BLANNING AMENDMENT

Application No. H23/0108/03/H1
Date Registered 08 APR 2003
Case Officer DMG

PROPOSED EXTENSION ABOVE
GARAGE

Amendment: Revised internal layout to prevent overlooking
Floor layout and elevational plans Rev.A.

FIRST FLOOR PLAN AS PROPOSED

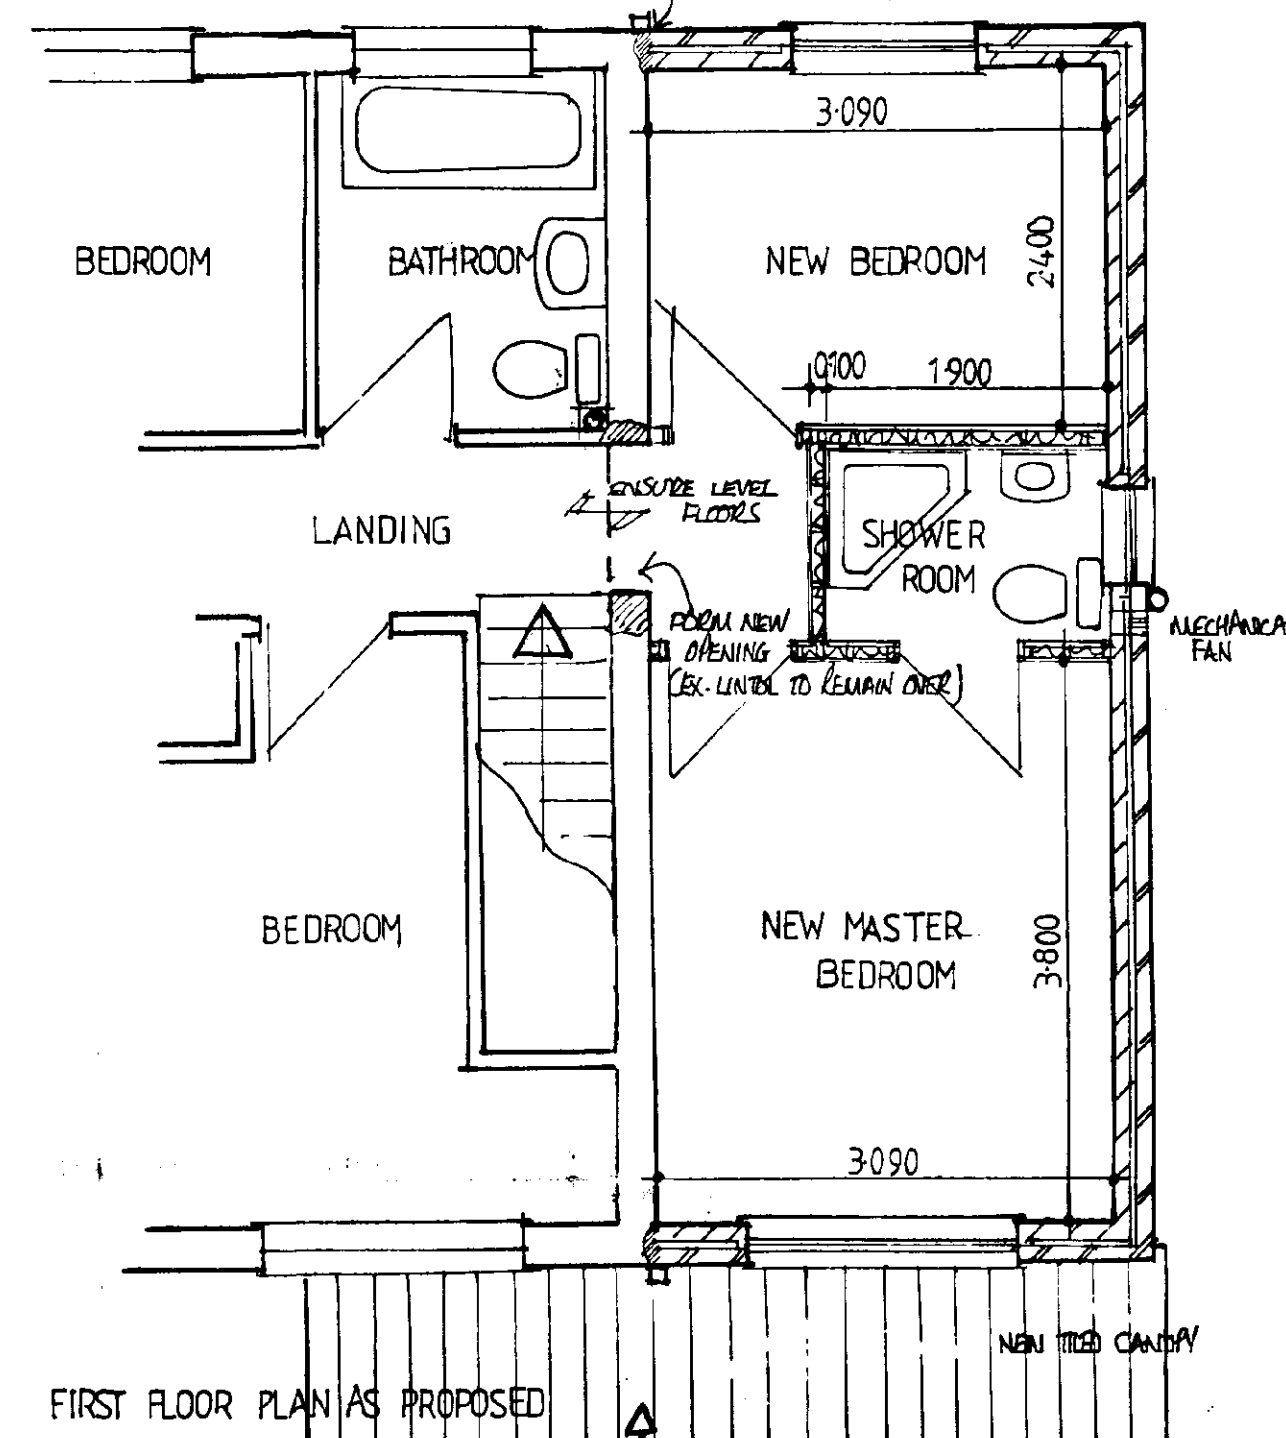
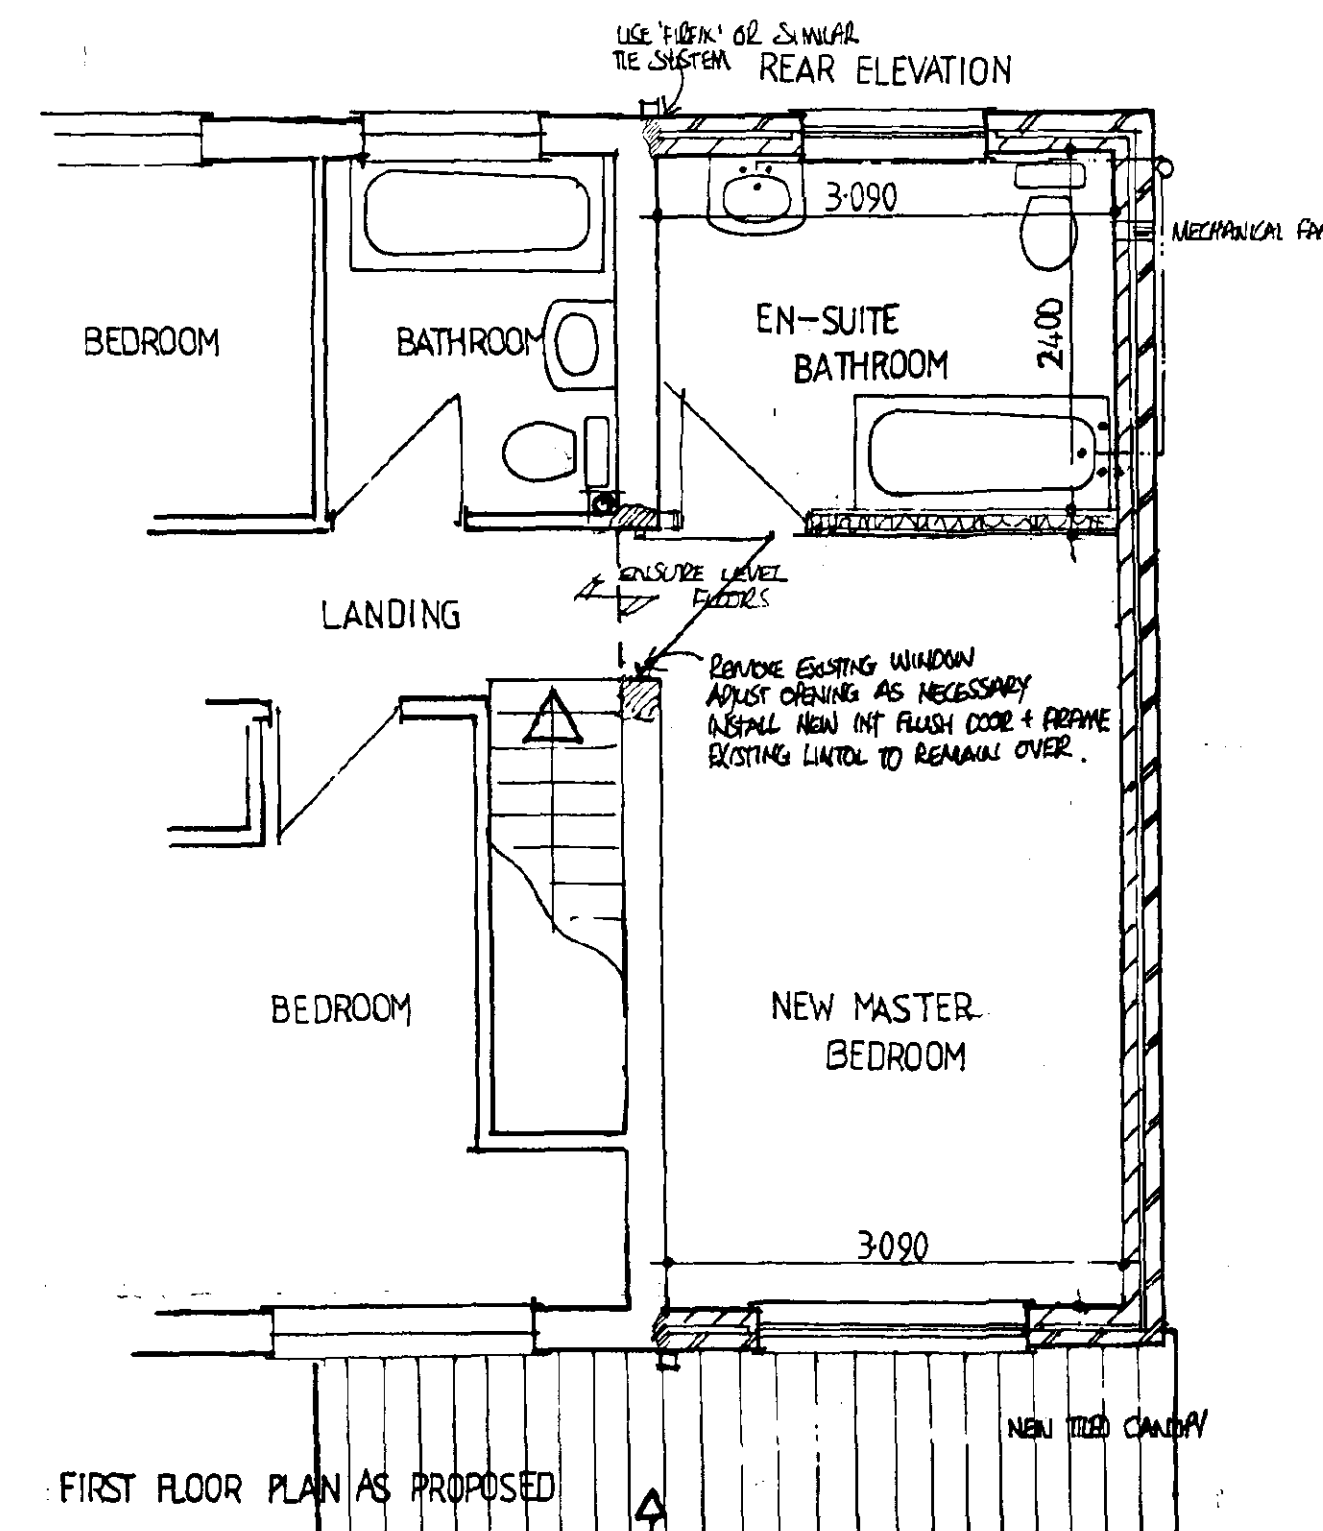
REAR BEDROOM RE-MOVED TO
BE EN-SUITE.
REASON: - TO PREVENT OVERLOOKING
